Application SSI 7485

The proposed modification to the Crescent overpass have recently come to my attention – M4-M5 Link Mod 2.

Figure 4-5 The Crescent/Johnston Street/Chapman Road intersection

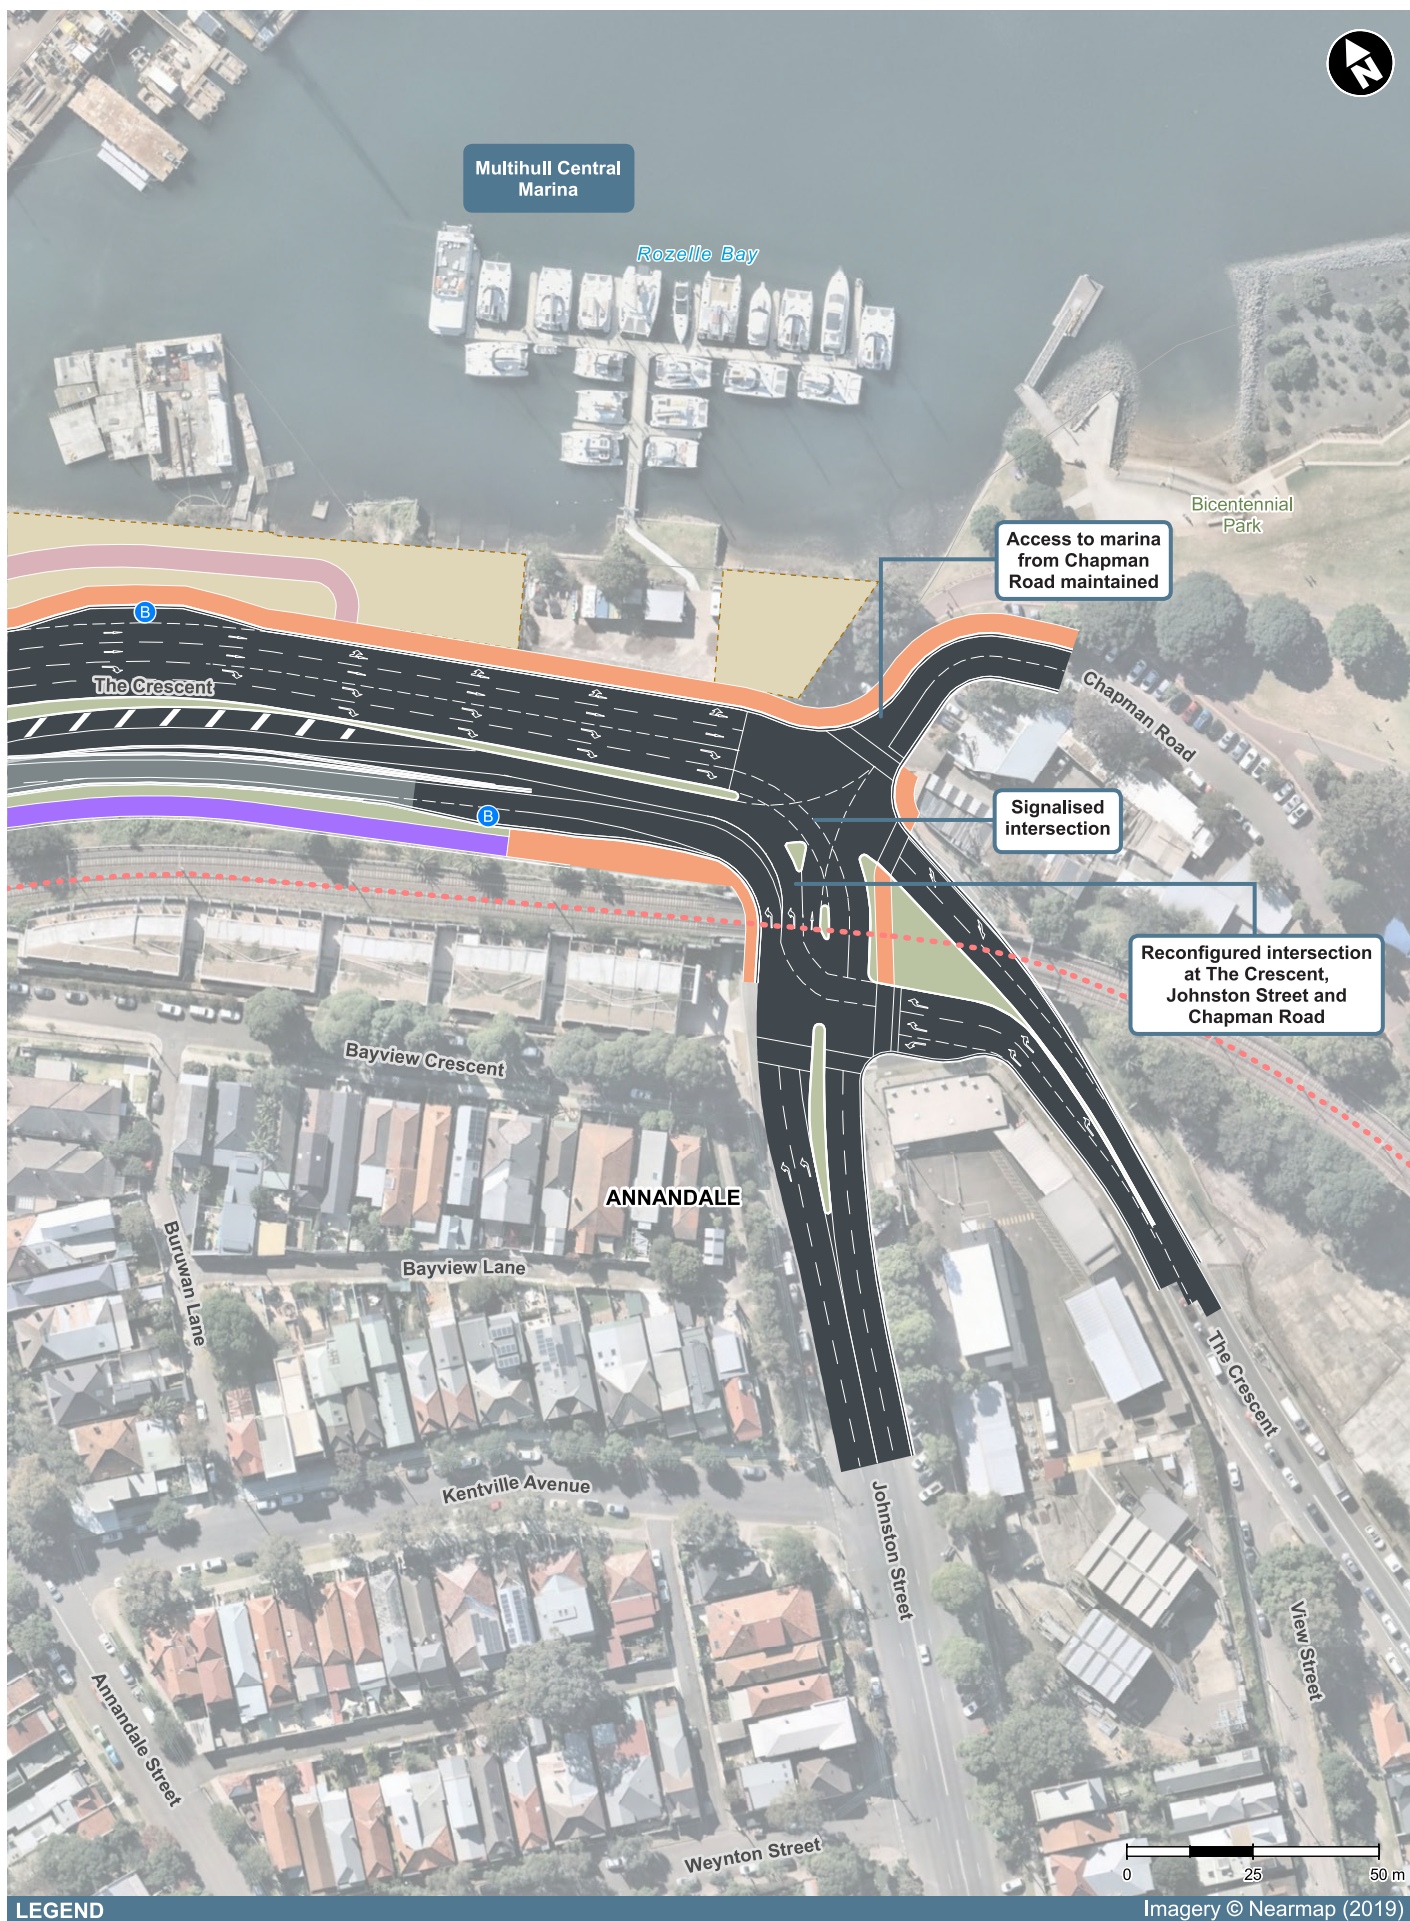
I am now dismayed and angry to discover that this Green Link would not go ahead with the proposed modifications, and instead there would be several sets of pedestrian lights to cross at the Crescent in order to reach the foreshore at Annandale.

Figure 4-6 Elevation: Indicative view of Rozelle Rail Yards Pedestrian and Cycling Green Link

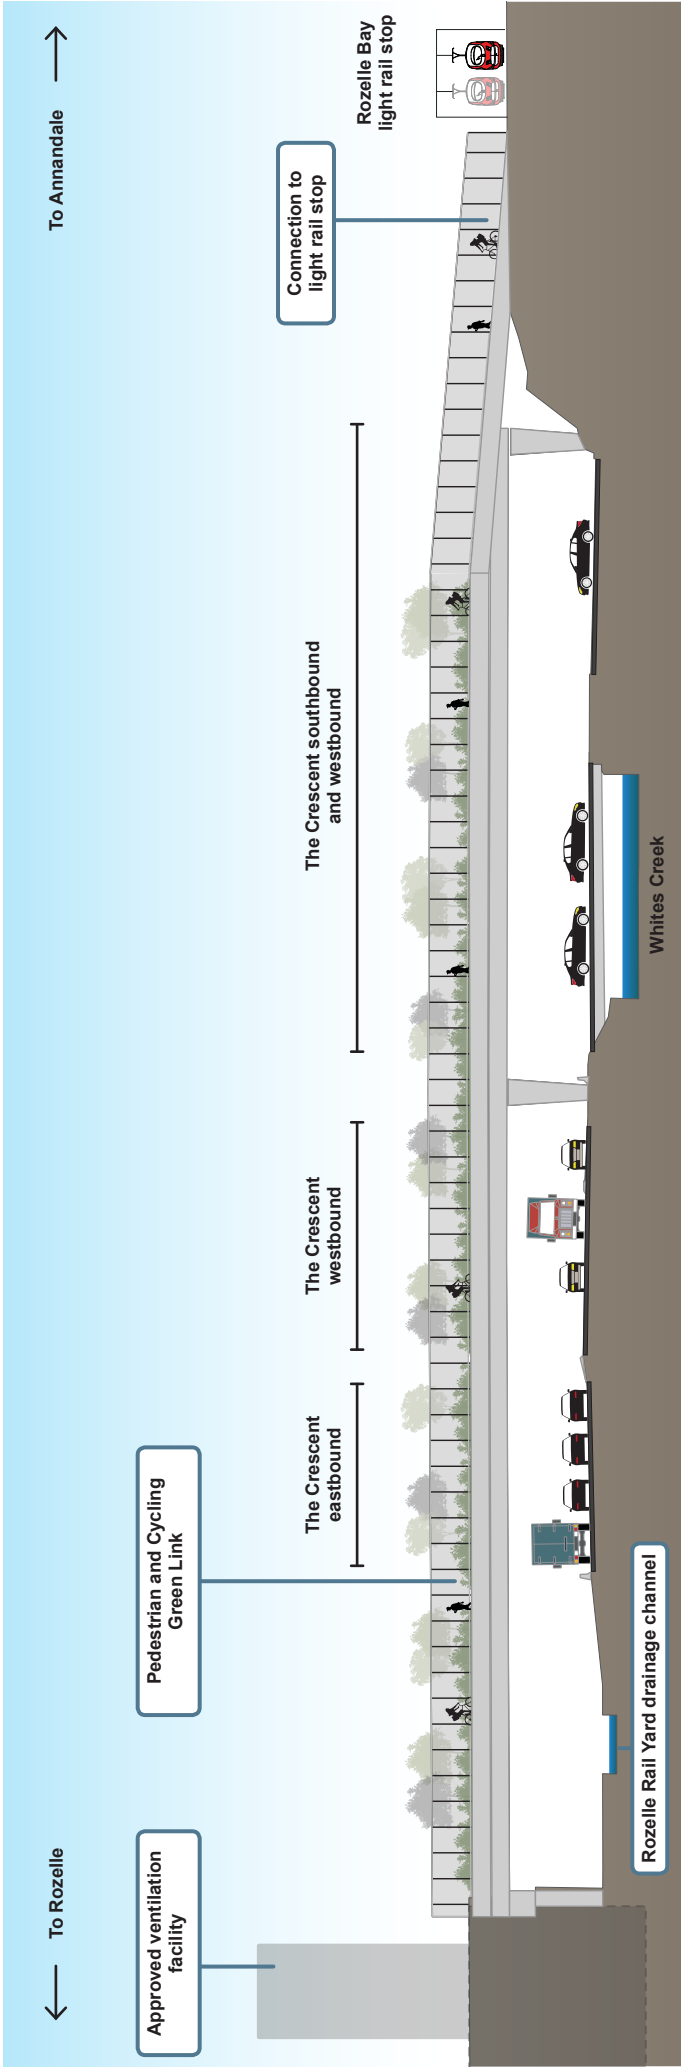
I strongly value the amenity promised by the Green Link, with safe, level, continuous pedestrian and cycling free flow between Rozelle and Annandale.
